From: Simon Davis
Sent: Tuesday, February 13, 2024 5:19 PM
To: 'Ruth Harding' [REDACTED]
Subject: RE: BR/97/22/PL Royal Bay

Lastly, I note that amended plans (Location Plan, GF Layout, Addendum DAS and 3 x photos) were received by us on 06/09/23 but these have not been added to the file by either of the previous officers. Please advise whether you still want these adding to the submission. Can you also advise what the changes were as, assuming these do need to be added, I need to determine whether it is necessary to re-consult anyone.

From: Ruth Harding [REDACTED]
Sent: Monday, February 12, 2024 5:06 PM
To: Simon Davis <Simon.Davis@arun.gov.uk>
Subject: RE: BR/97/22/PL Royal Bay

Royal Bay (Application Reference BR/97/22/PL) - External Amenity Areas

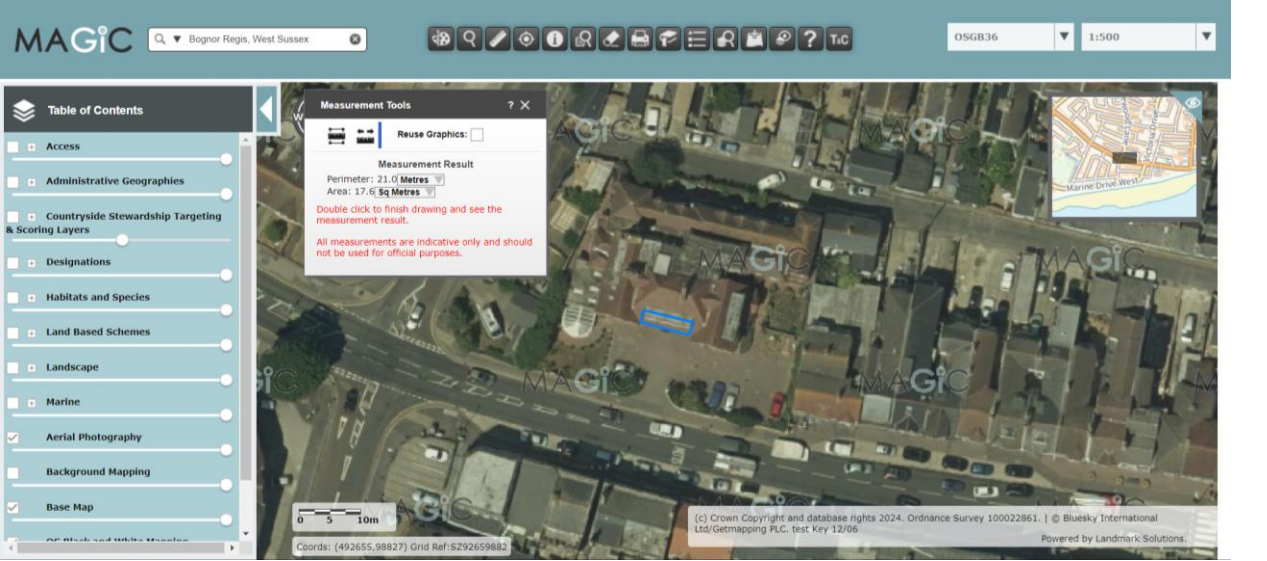
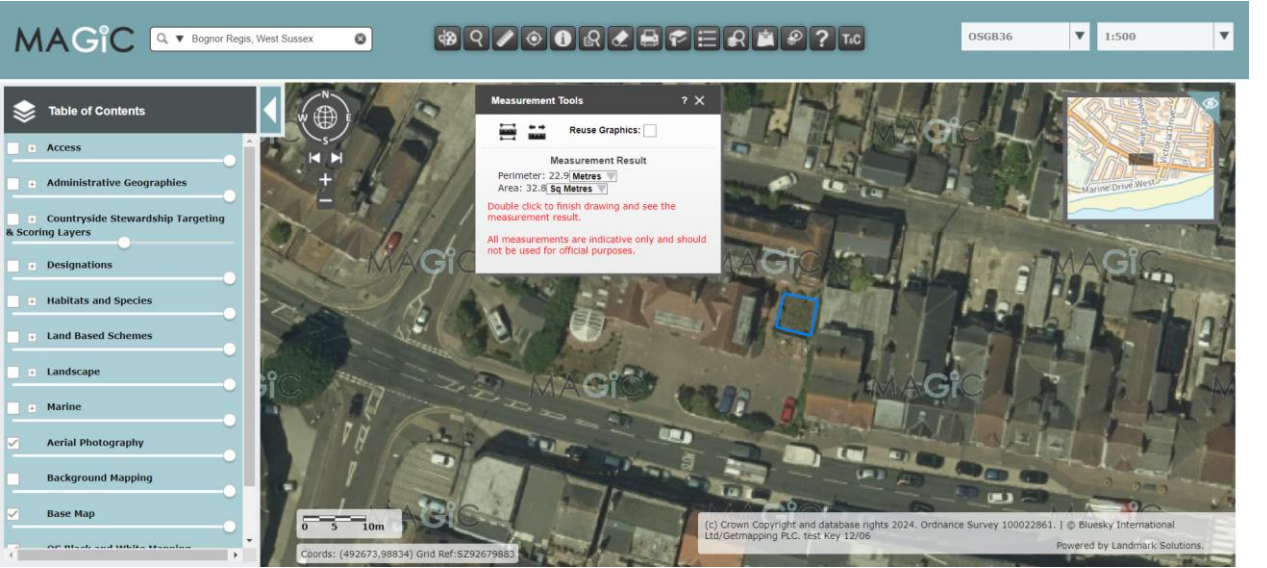
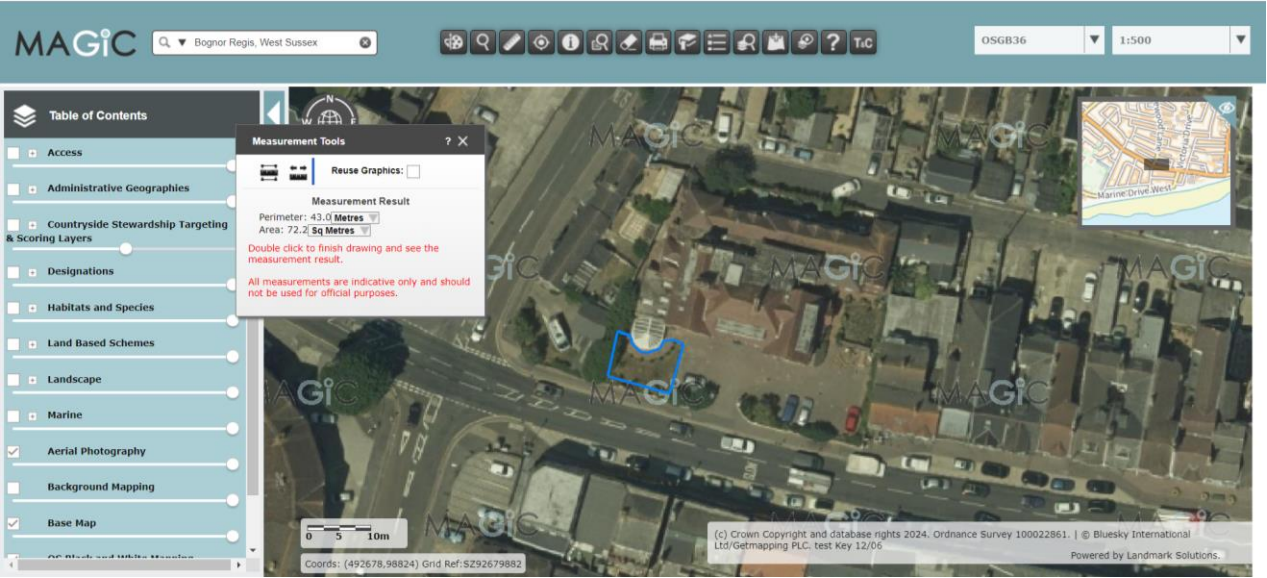
The amenity space 'drawing' is acceptable for our purposes and so I consider this point closed.

I have spoken to my Team Leader regarding the amenity space issue. We have had regard to your comments on the space available, the quality of the spaces, the proximity to nearby public recreation areas and the recent appeal decisions. In conclusion, we can agree that the space the site offers is acceptable but provided you can supply us with a plan which we can put on the file that clearly shows the 133m2 that is claimed. Whilst, we have identified the areas you talk about, the plan you provided to Maria in September does not indicate all of these areas and is not to scale.

Regarding the amenity space, I trust you can accept the attached document. The map extracts are derived from Magic Maps and are accurate measuring tools. They demonstrate the amount of amenity space that is related to the property and thereby should be sufficient for the Council's purposes to assess this aspect of the application. To obtain a revised layout plan will require the Applicant to source and instruct a measured survey plan which will add further time and cost to the process. I would also add, in any event, adherence to the Council's guidance on amenity space should not be determinative, particularly given that the decision-making process should be based on the 'tilted balance' set out in the NPPF (i.e. any adverse impacts would need to significantly and demonstrably outweigh the benefits). I would appreciate your confirmation on this particular matter.
